Chris Greig - 97100195
File Ref: DN11/0003

25 May 2012

Your Reference: MP11_0009 (Part 3A Application)

Proposal: Miranda Dental Hospital at 84-86 Kiora Road, Miranda

basement floor plan
scale: 1:100

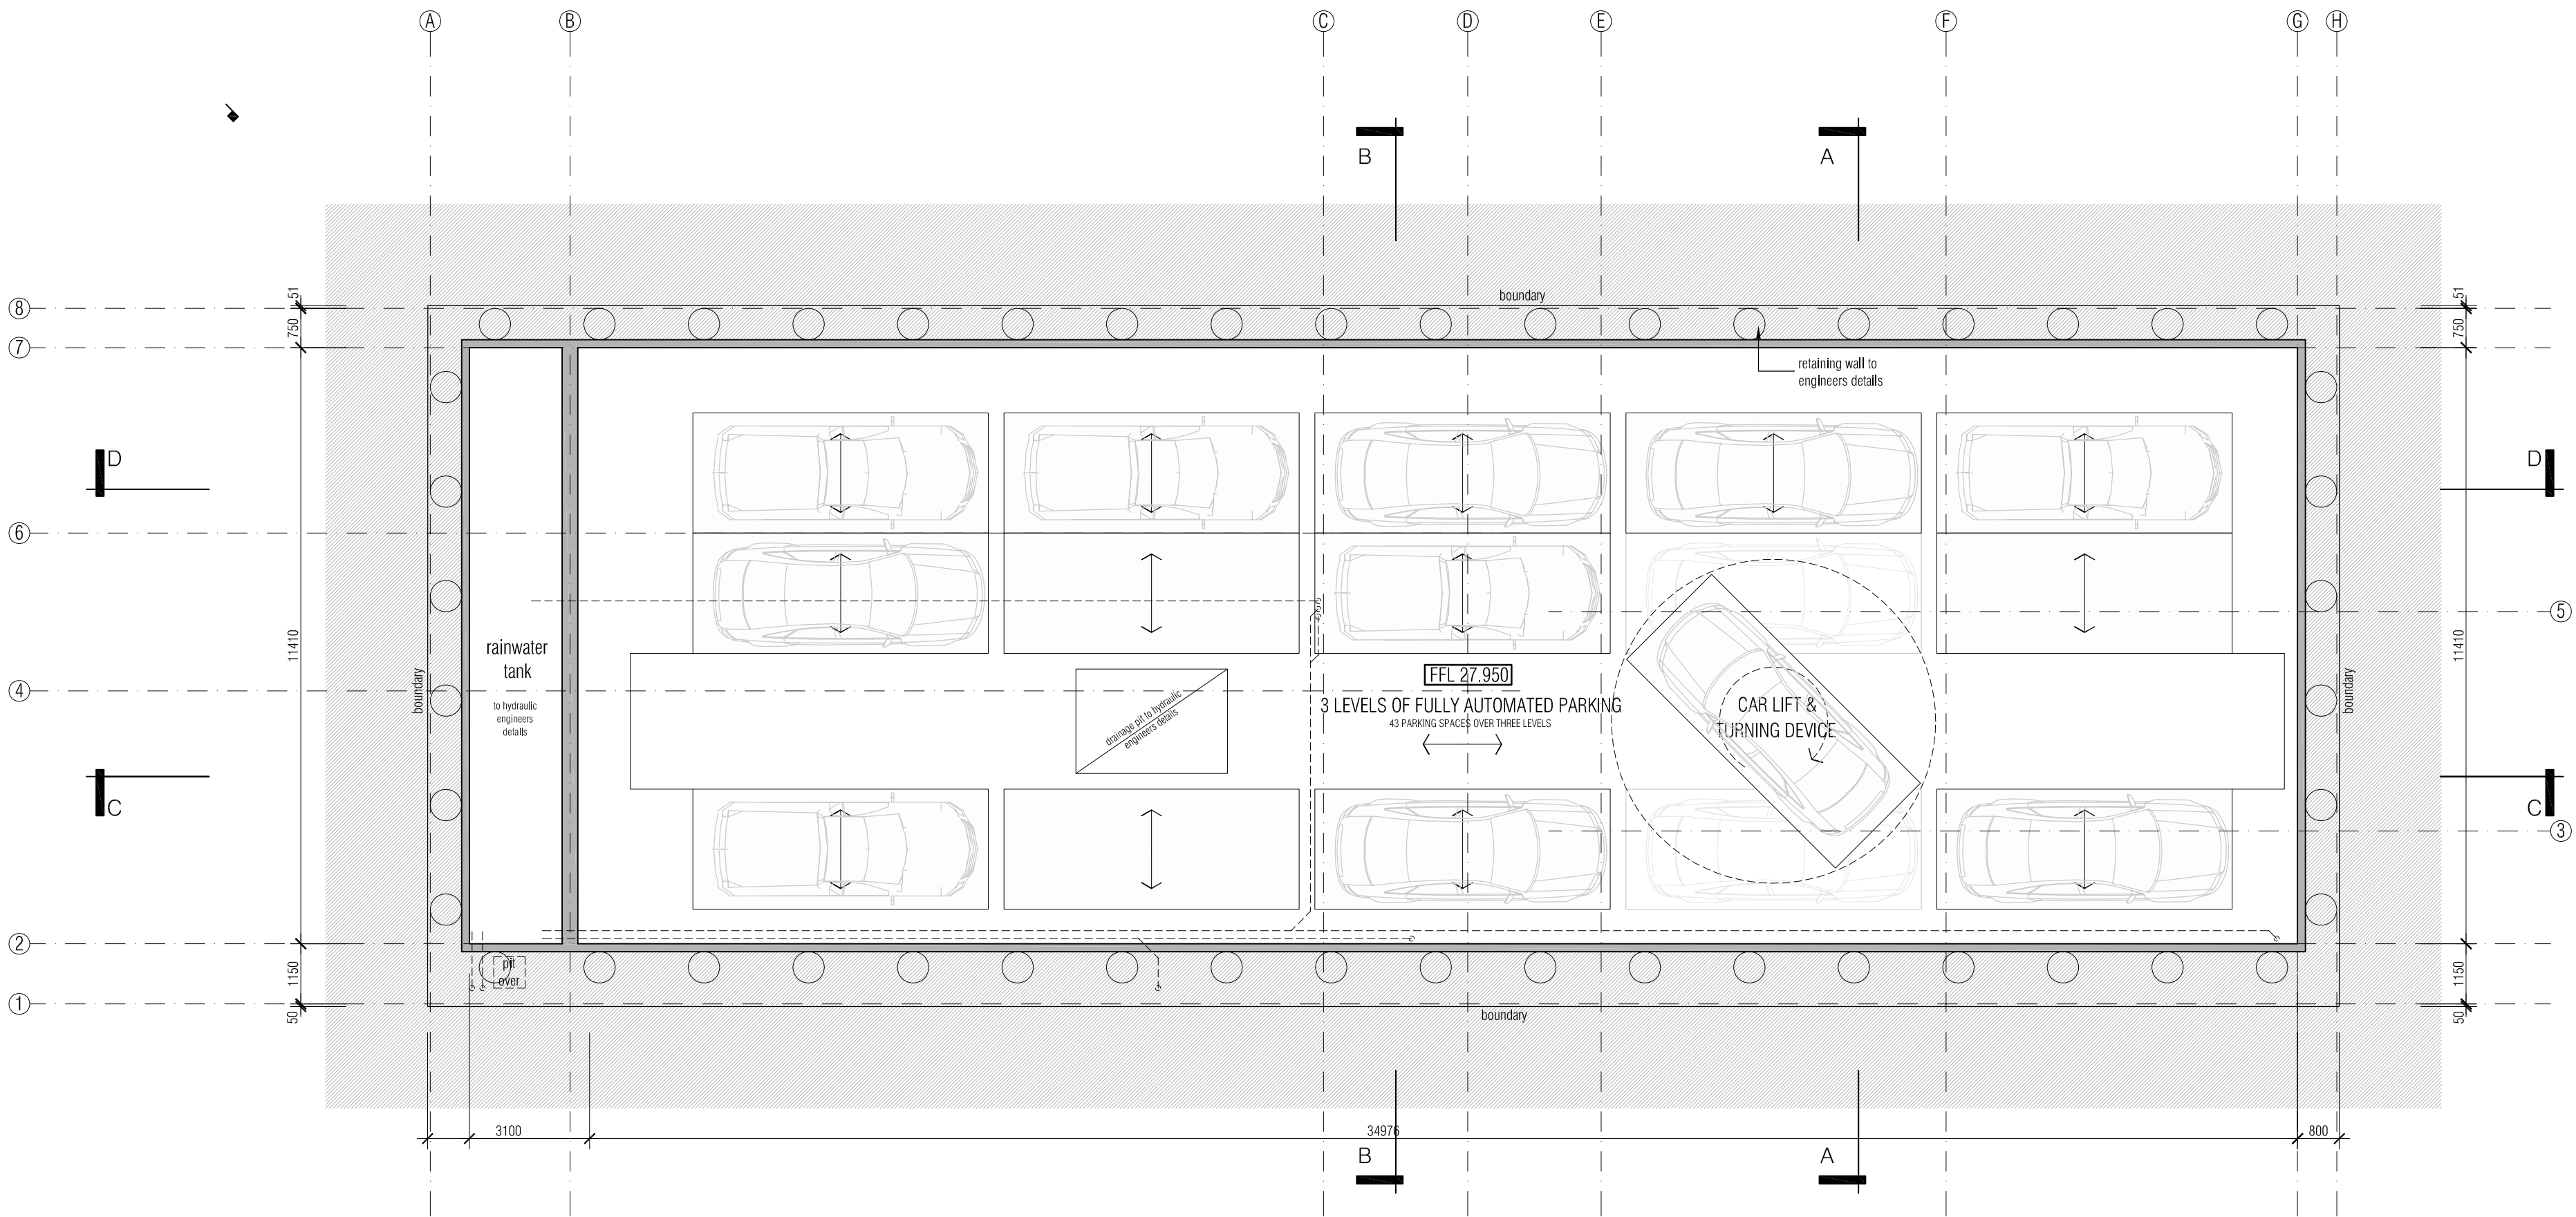
A total of 40 carparking spaces (30 for staff and 10 for visitors) are now proposed within the basement in lieu of the original 43 spaces. No readily accessible designated disabled space has been shown, and a valet service proposed instead. The functionality of the parking system has been improved with the intention of avoiding queuing onto public roads.

There is no credible evidence provided to suggest that 10 spaces for patients would cater for the likely demand from patients arriving by car. Given the number of treatment rooms shown on the plans, logic would suggest that the demand would far exceed the number of spaces provided for both staff and patients.

In summary the reduction in the number of parking spaces and the introduction of a valet are not considered to have addressed the significant shortfall in on site parking.

- A condition has been included requiring that a valet be employed/contracted on a permanent basis and be stationed in the driveway apron area whilst ever the premises is trading/in use. Further, that there be adequate signage, visible to Urunga Parade, indicating that parking is provided within the facility for patients.

lower ground floor plan
scale: 1:100

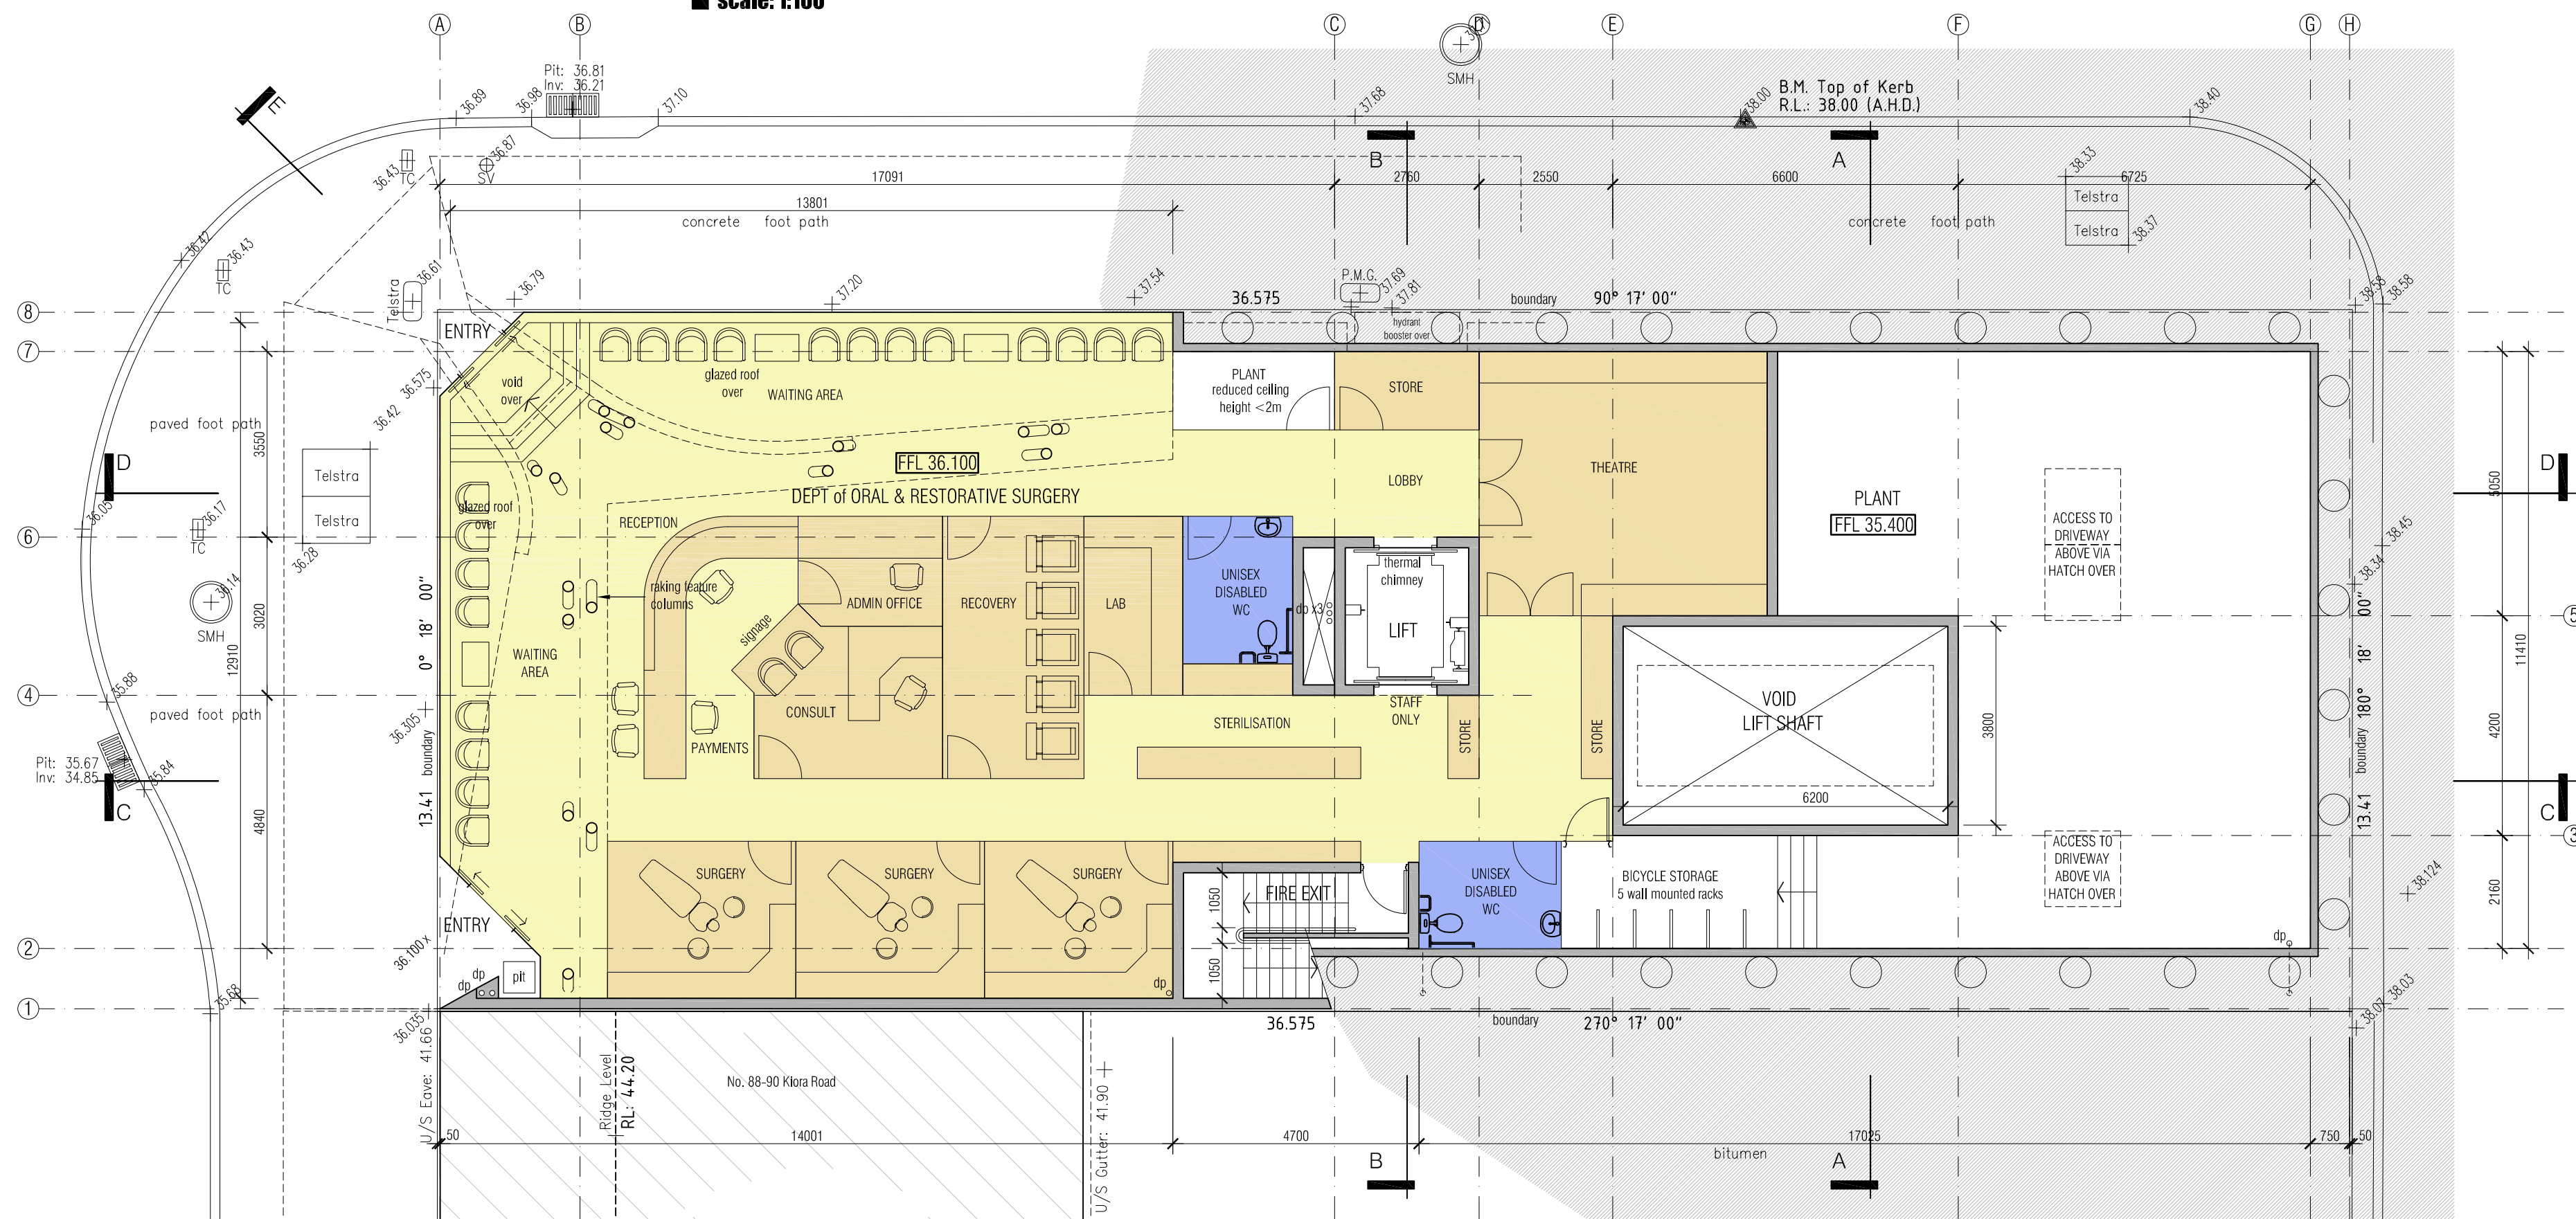
The revised plans and information do not provide a colonnade to Kiora Road as recommended by Council, and only superficially address the future treatment that may be carried out to the glazing of the upper two levels of the south facing wall should the adjoining site be developed to a similar scale and height.

Council is still of the view that provision of a colonnade is a reasonable contribution to the public domain in response to the concessions being sought by the applicant in relation to floor space and car parking. A colonnade will provide improved amenity for visitors to the subject site (which will be a high pedestrian generator), consistency with the colonnade treatment provided by Westfield, and ultimately a better pedestrian connection to the station.

- A condition has been included to provide for a 3.0m wide colonnade for the full width of the site and wholly within the Kiora Road setback, as previously recommended;

A 3m deep set back is to be provided to the Kiora Road street frontage at the lower ground floor level. The set back is to provide a continuous colonnade for the full Kiora road frontage. Finished floor levels throughout the colonnade must be consistent with the adjoining public footpath pavement, levels of which shall be provided by Sutherland Shire Council within the required Roads Act approval.
